Our ref: DOC20/853471
Senders ref: SSD-9619

RE: Tilbuster Solar Farm (SSD9619) Aboriginal Cultural Heritage Assessment

Thank you for your referral uploaded to the major projects portal on 15 October 2020 inviting comments from Heritage NSW on the Aboriginal Cultural Heritage Assessment Report (ACHAR) for the construction of a solar farm and associated infrastructure at Tilbuster approximately 17 kilometres north of Armidale in the Armidale Regional local government area.

Tilbuster Solar Farm Sites In Relation To Development Footprint

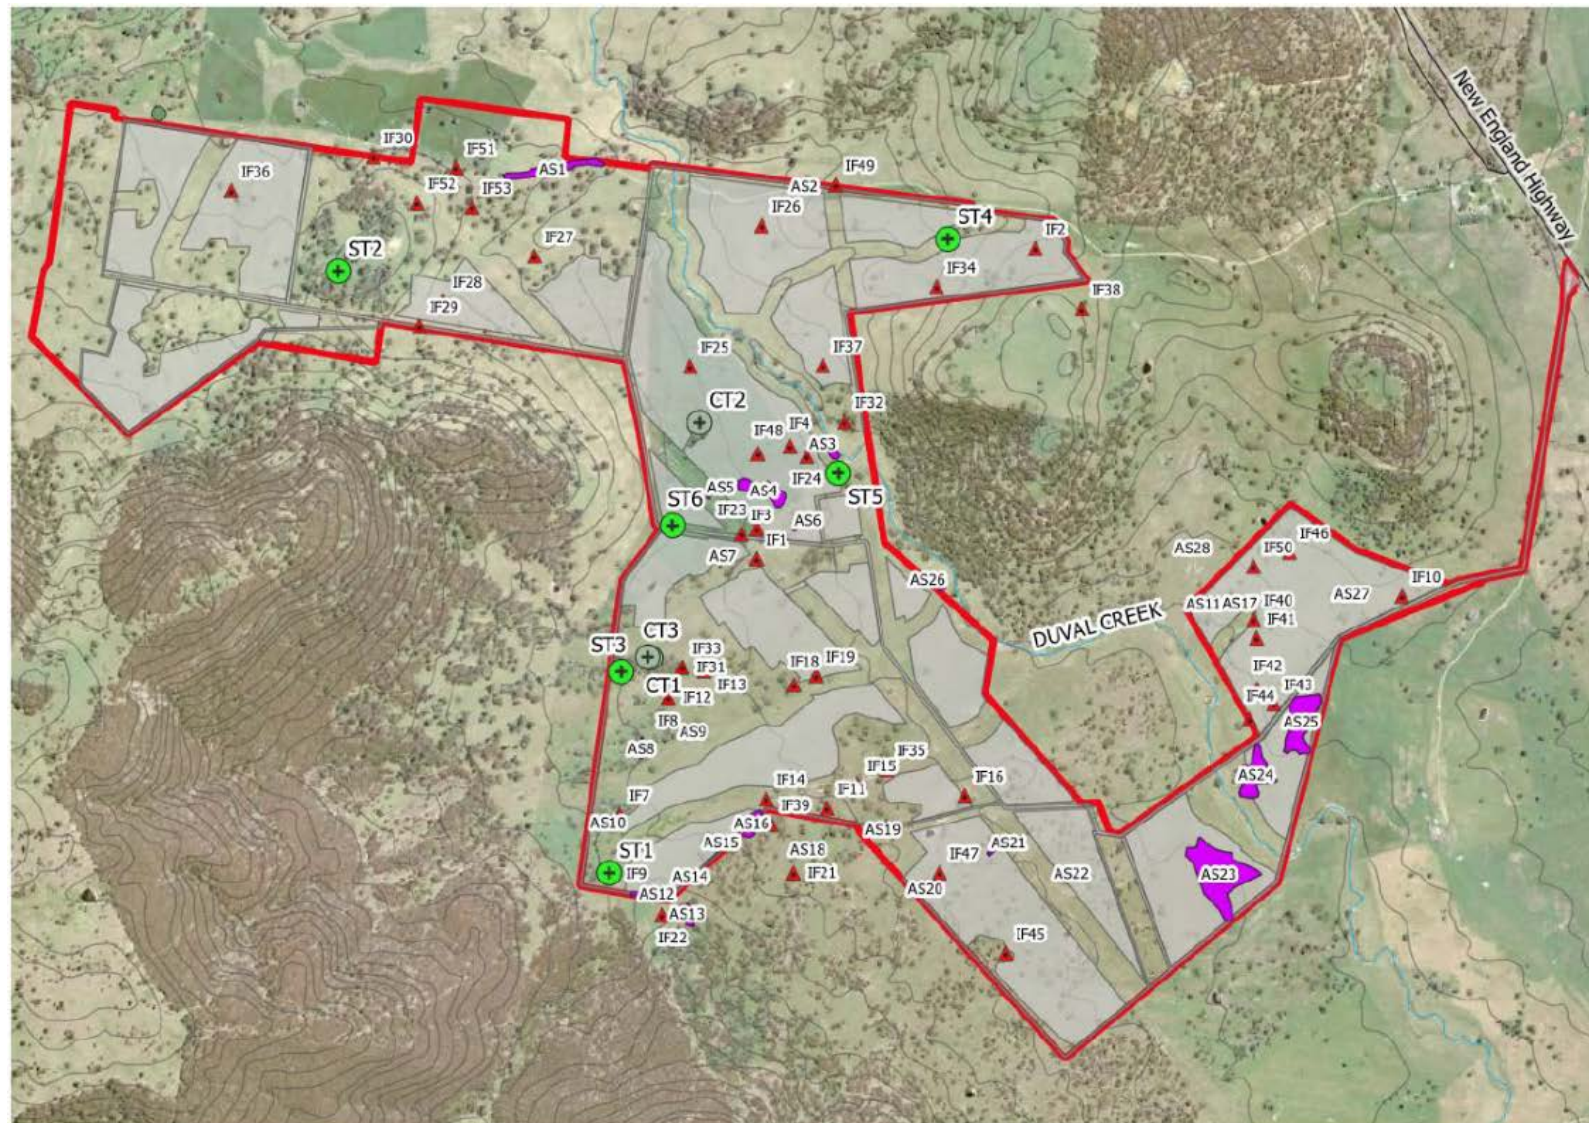
We have reviewed the ACHAR, and concur with the findings and support the recommendations therein. We note that the current project footprint includes a number of Aboriginal scar trees which will be directly or indirectly harmed by the proposal. Heritage NSW considers all Aboriginal scar trees to be of high scientific and cultural value. We note the recommendations in Section 9 of the ACHAR to redesign the project footprint so as to avoid harm to all Aboriginal scar trees and we support those recommendations. Heritage NSW strongly opposes any approval which would result in direct, or indirect, harm to any Aboriginal scar trees.
